24 January 2019  
218001

**RE. SSD 9275 - Response to Submissions  
80-88 Regent Street, Redfern**

## 1.0 Design Modifications

Elevation East

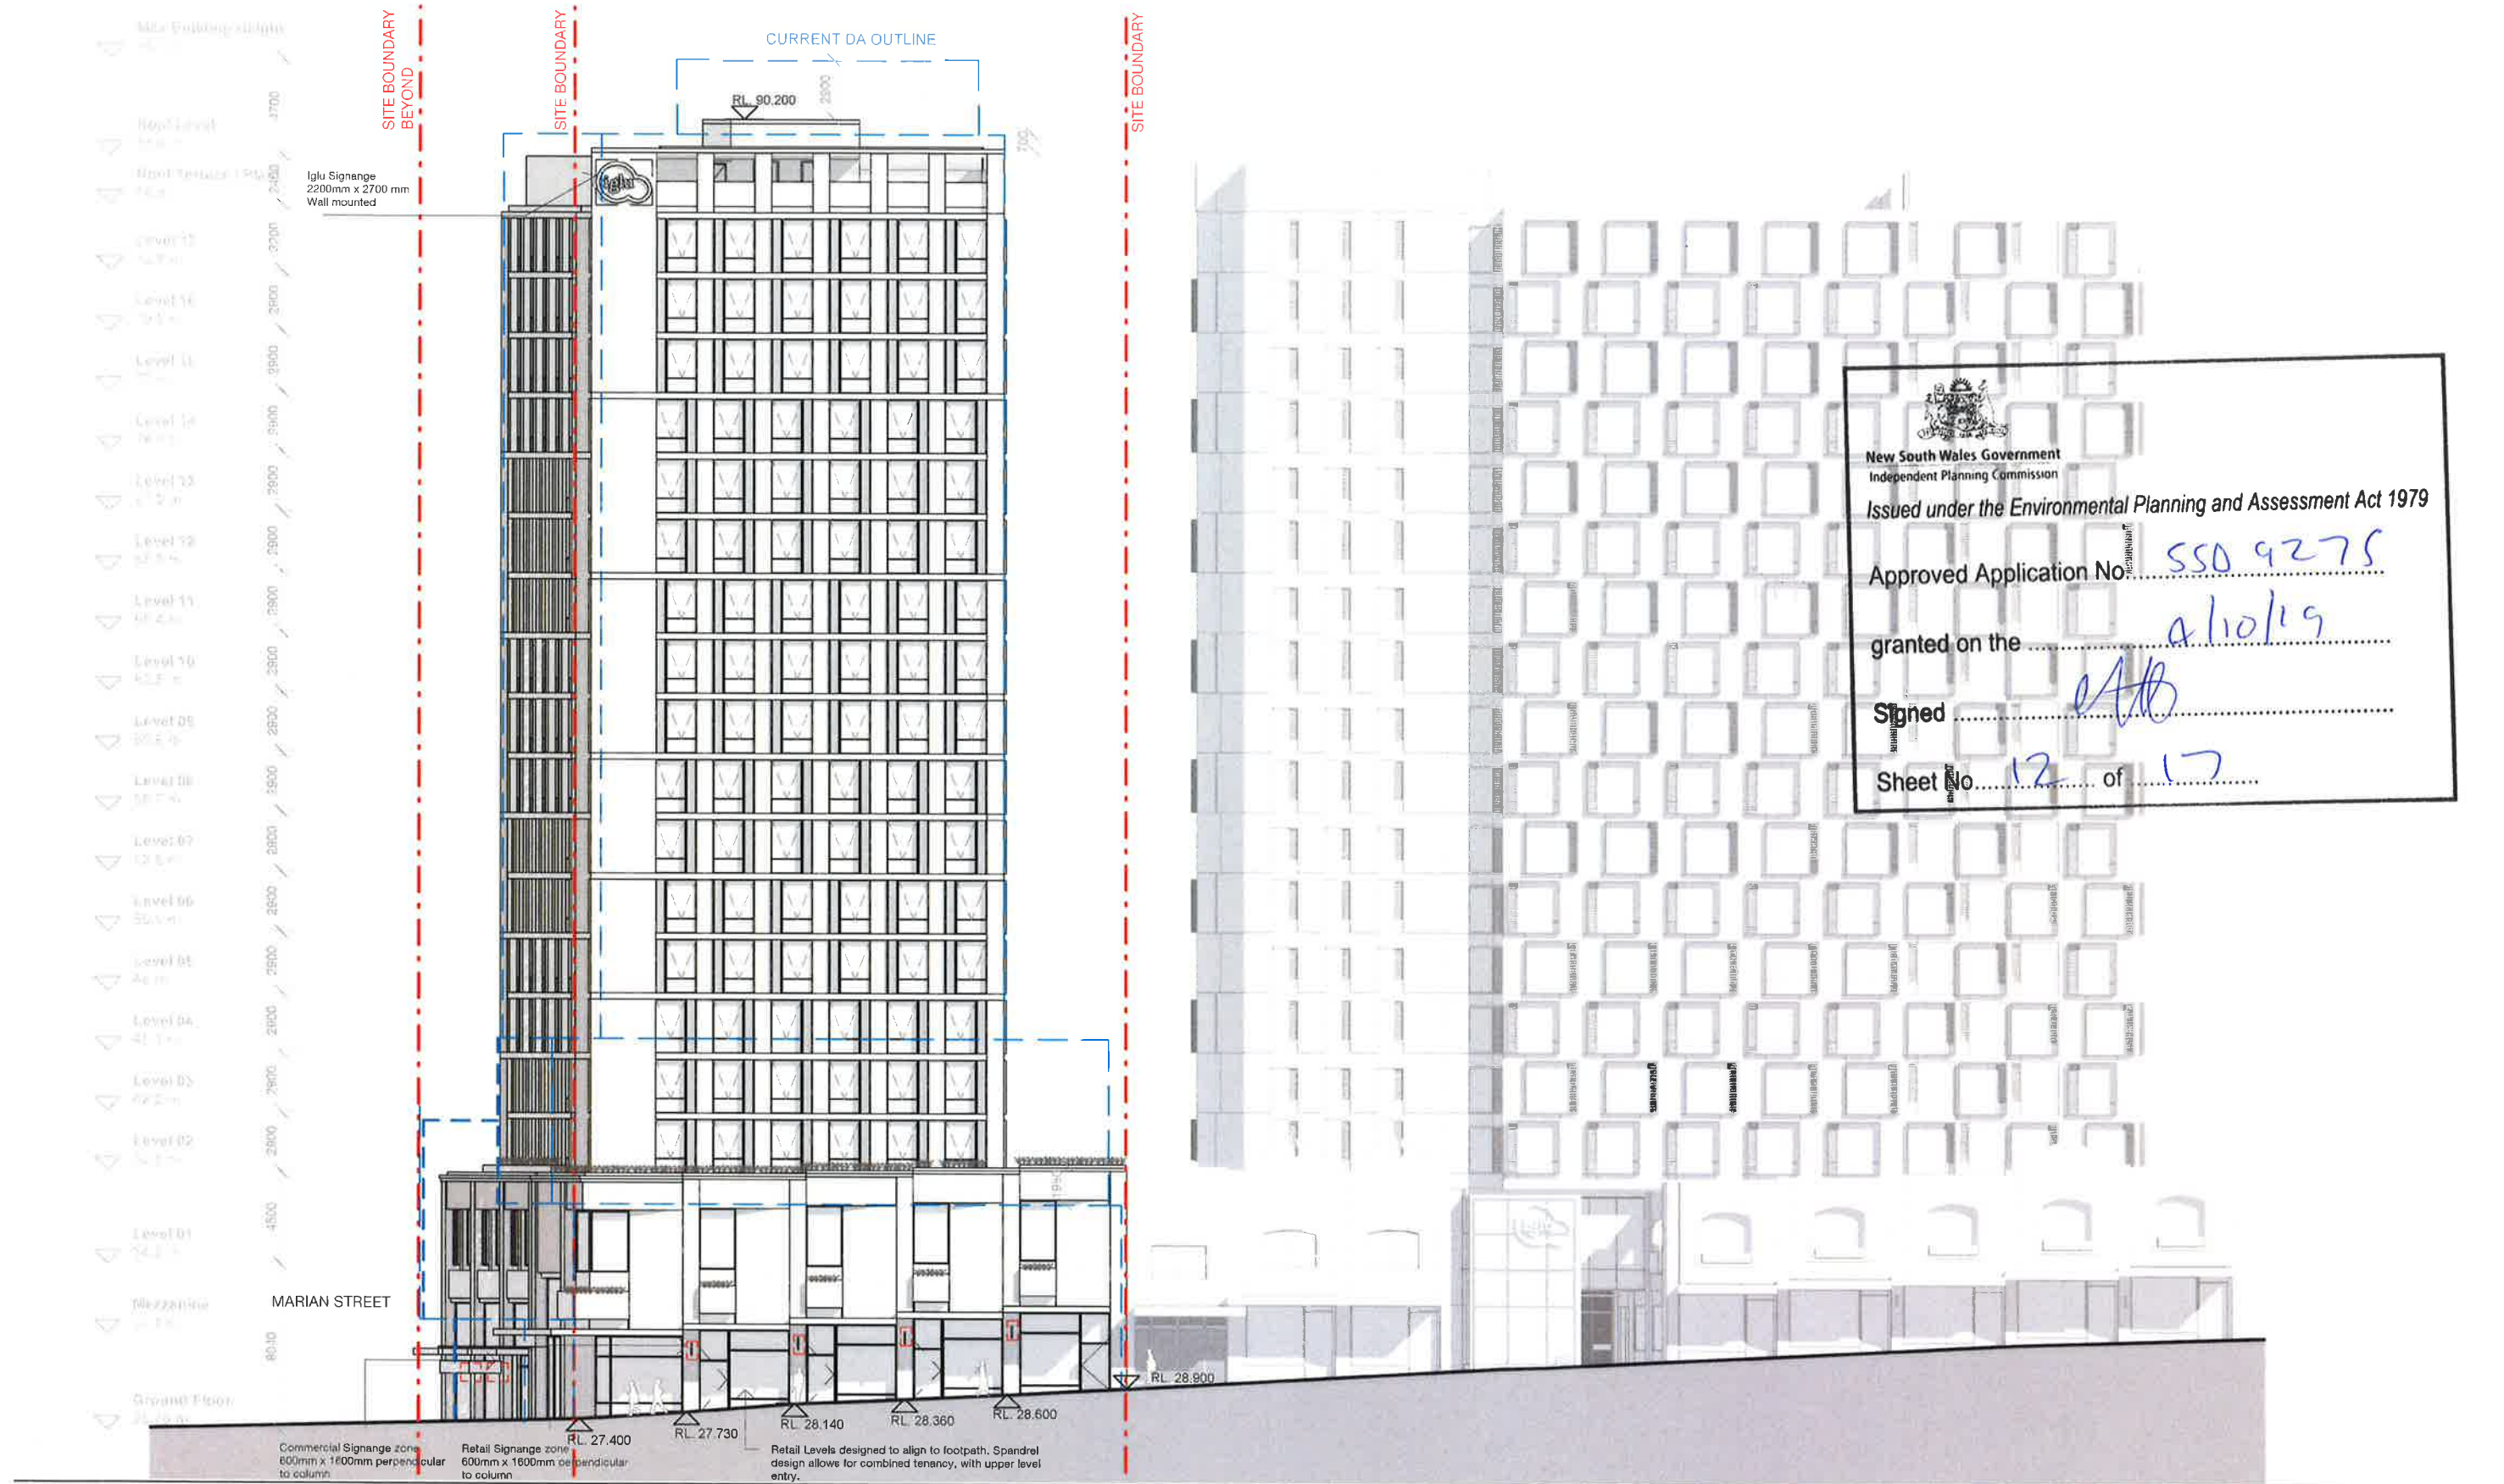
In response to the GANSW's recommendation, the proposed awning has been redesigned. Specifically, GANSW suggested the height of the stepped awning height at the corner of Regent Street and Marian Street be reconsidered to achieve sufficient and consistent weather protection along the footpath for pedestrians. In addition to this, the Department acknowledged Windtech's recommendation to avoid breaks in the awning along Marian Street had not been incorporated into the design.

Accordingly, the amended awning design responds to the topography of the site by stepping down Regent Street, with the height at the Regent Street and Marian Street corner lowered to provide improved weather protection. Further to this, the breaks in the awning along Marian Street have been deleted to minimise wind downdraft.
